Review Comments by the Colorado Geological Survey – 5/6/2024

CGS Unique No.: EP-24-0047_2 Retreat at Prairie Ridge Preliminary Plan Phase 1 (AKA Jaynes)

EP File Number: SP239, 217 SF lots and 6 rural residential lots on 108.89 acres for future residential development

The available referral documents include a Soil and Geology Study and Wastewater Study, Jaynes Property – Preliminary Plan (Entech Engineering, Job No. 212381, Revised April 2, 2024), Preliminary Plan (Classic Consulting, April 1, 2024), Letter of Intent (N.E.S., Inc., April 2024), and other documents. CGS provided comments on January 25, 2024, some of which are repeated herein.

GEOLOGY/ENGINEERING MAP
 JAYNES SITE
 POCO ROAD & VOLLMER ROAD
 EL PASO COUNTY, CO
 ELITE PROPERTIES OF AMERICA, INC.

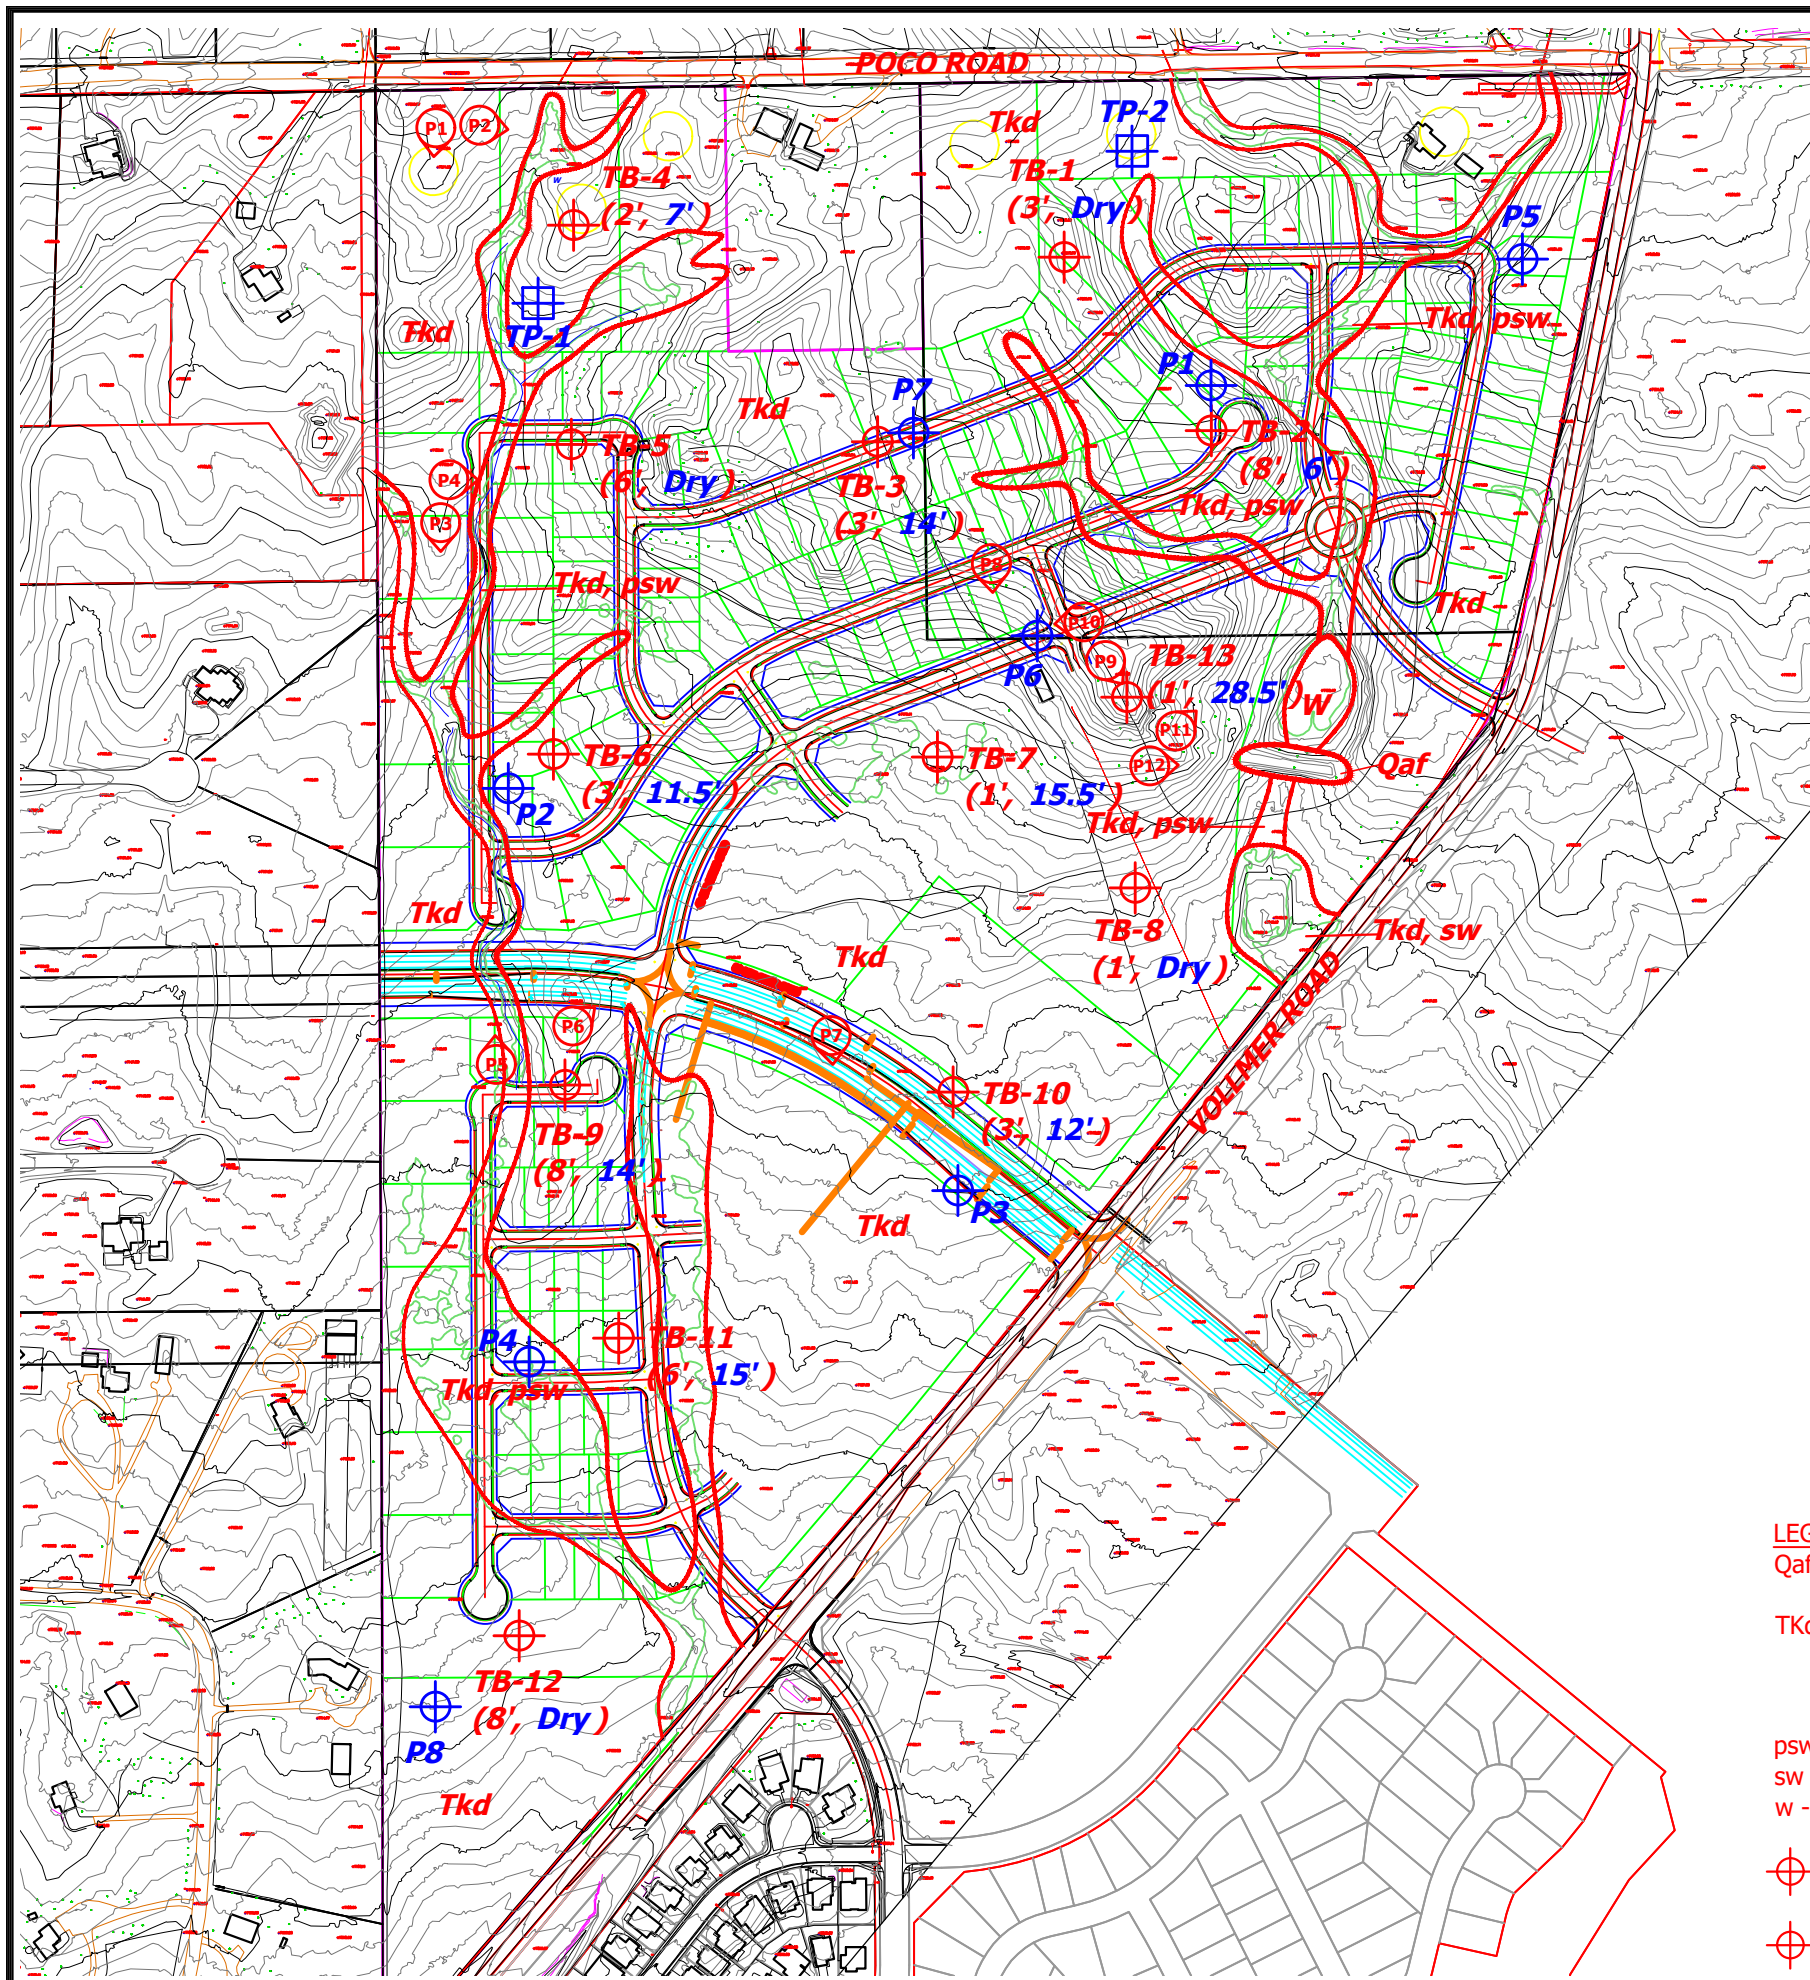
2. Test Boring 4, P2, P3, and P4 show groundwater at depths of 6.5 to 11.5 feet below grade. These areas are depicted as TKd (Dawson Formation) in Figure 8 of Entech’s report and Sheet 28 of the preliminary plan. These areas also contain potentially seasonally shallow groundwater (psw) or seasonally wet area (sw) and should be updated.
